**SSD 6010 - One Residential Building (Student Accommodation) within Darling Drive Plot**

**Submission by:**

**Greg Seeto**

**29 July 2013**

SHADOW DIAGRAMS: PERSPECTIVE, SHOWING THE PEAK, WINTER SOLSTICE

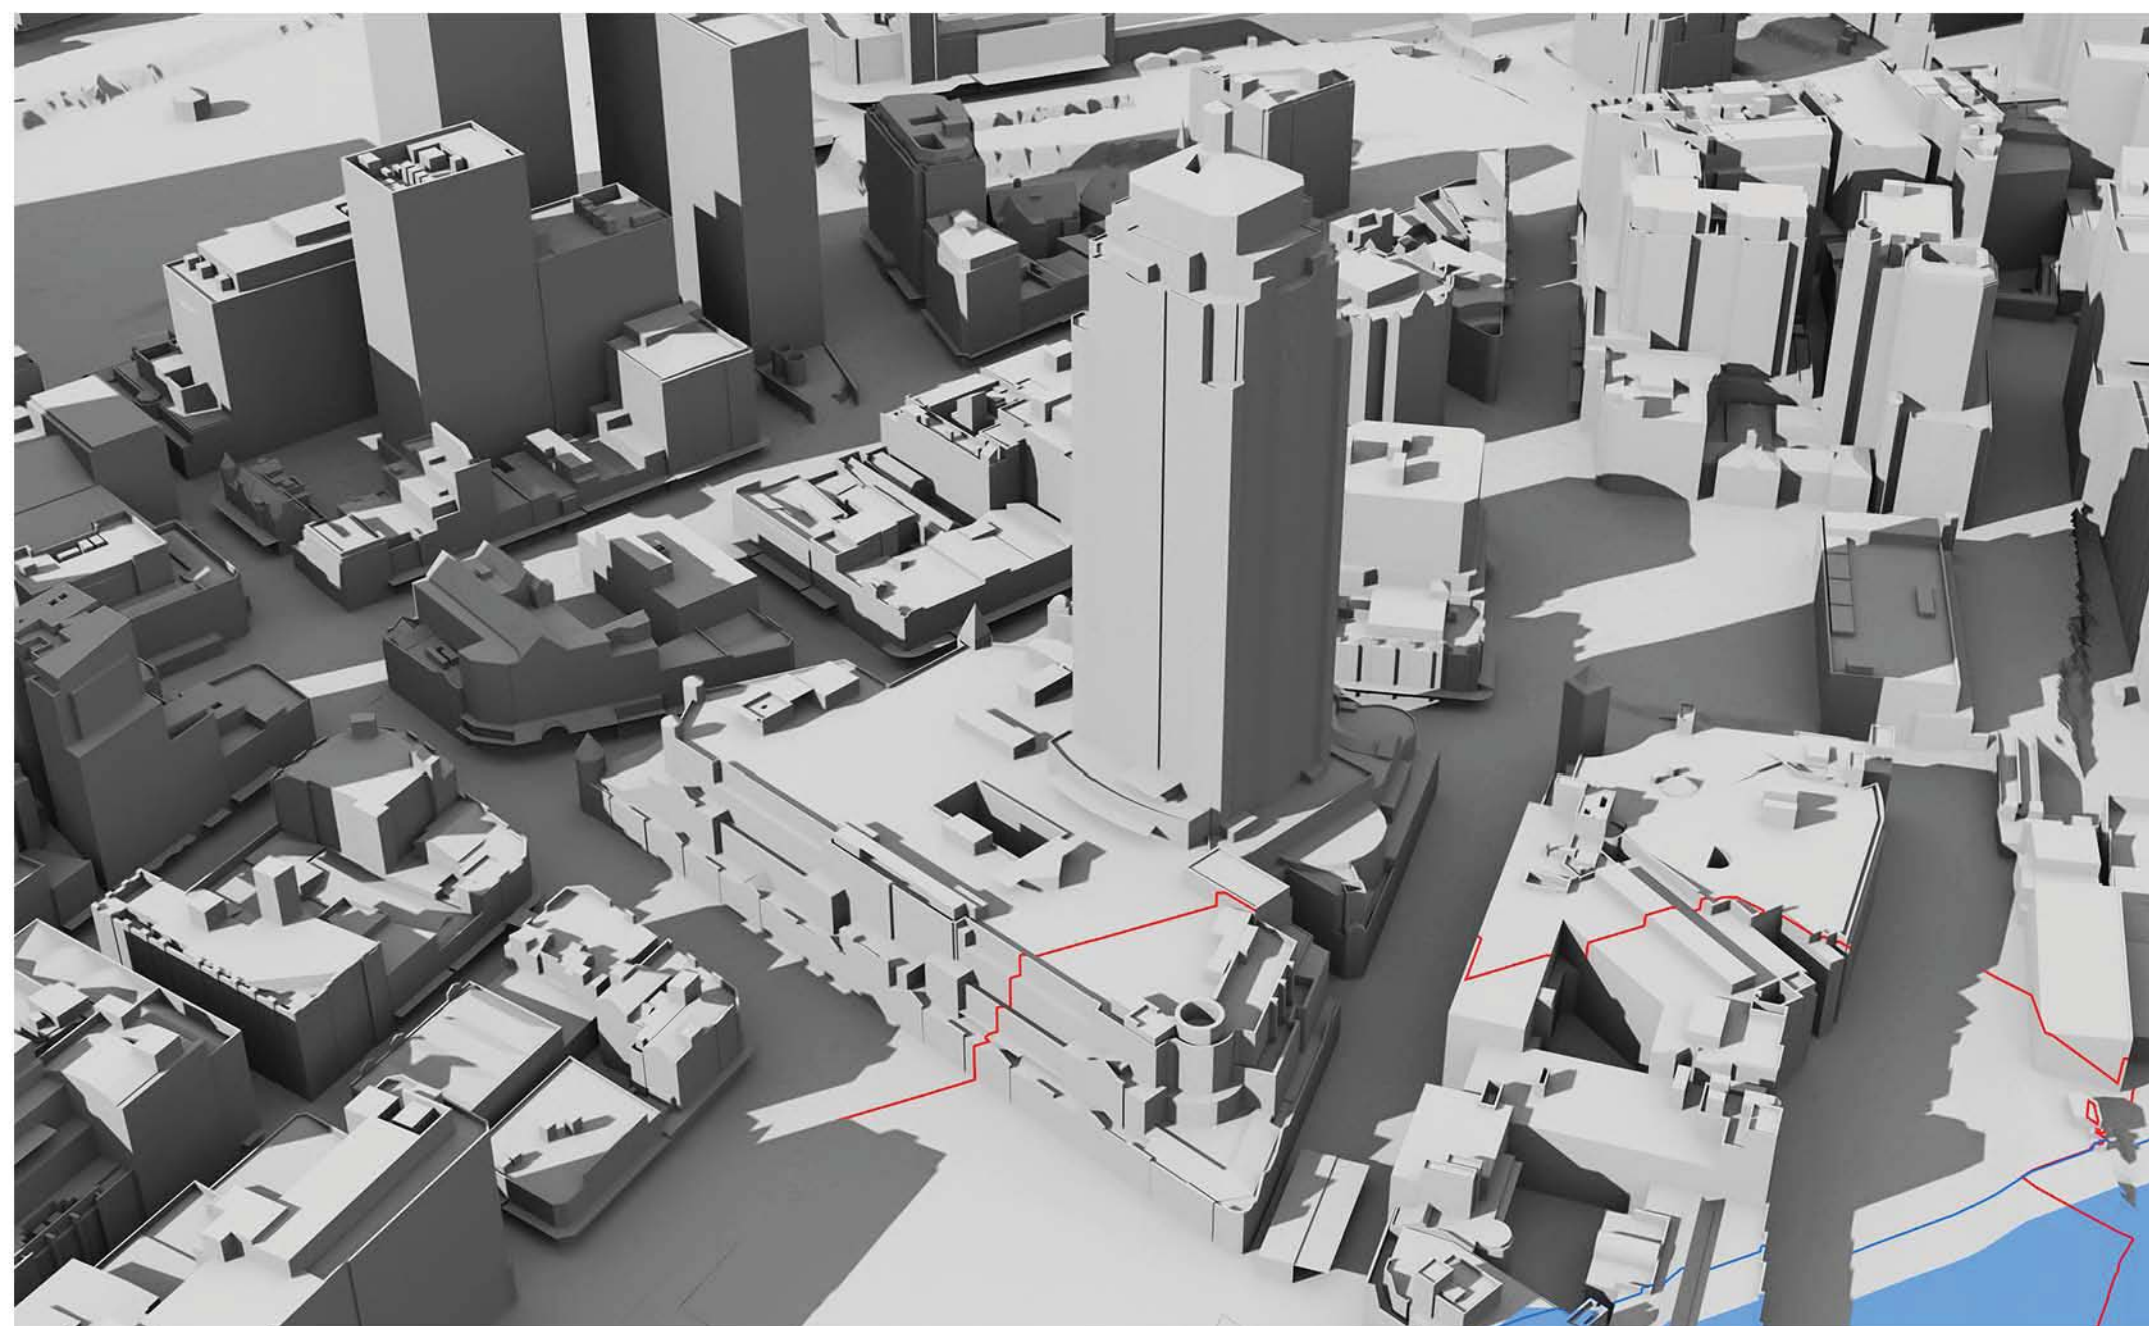
At 9am, 10am and 11am the west façade is totally in shadow due to other parts of The Peak building itself.

At 12pm there is still substantial existing shadowing on the west façade caused by the irregular shape of the west facade.

At 1pm the existing shadowing has been substantially removed, but not totally removed.

It can be concluded that some single aspect apartments on the west façade and some south-west dual aspect corner apartments currently receive less than 2 hours direct sunlight to habitable rooms and 50% of the private open space between 9am and 3pm on 21 June.

At 9am, 10am and 11am the west façade is totally in shadow due to other parts of The Peak building itself.

At 12pm there is still substantial existing shadowing on the west façade caused by the irregular shape of the west facade.

At 1pm the existing shadowing has been substantially, although not entirely, removed. However, overshadowing of lower levels of the west façade by the concept proposal parameter plan shadows for the N,NE and SE plots has already started.

By 2pm the existing shadowing has been totally removed. However, overshadowing of the west façade by the SSDA4 and SSDA5 buildings has appeared and risen further up the west façade than the concept proposal parameter plan shadows for the N,NE and SE plots, which is still present.

At 3pm, the proponent states correctly that 45-45% of the western façade is overshadowed by the SSDA4 and SSDA5 buildings.

It can be concluded that, as a result of combination of the proposed development with existing shadowing of the west façade, some single aspect apartments on the west façade and the south-west dual aspect corner apartments which currently receive less than 2 hours direct sunlight to habitable rooms and 50% of the private open space between 9am and 3pm on 21 June will suffer additional overshadowing. It is beyond our skills to count the number of such apartments. We note that the proponent has made no attempt to do so.
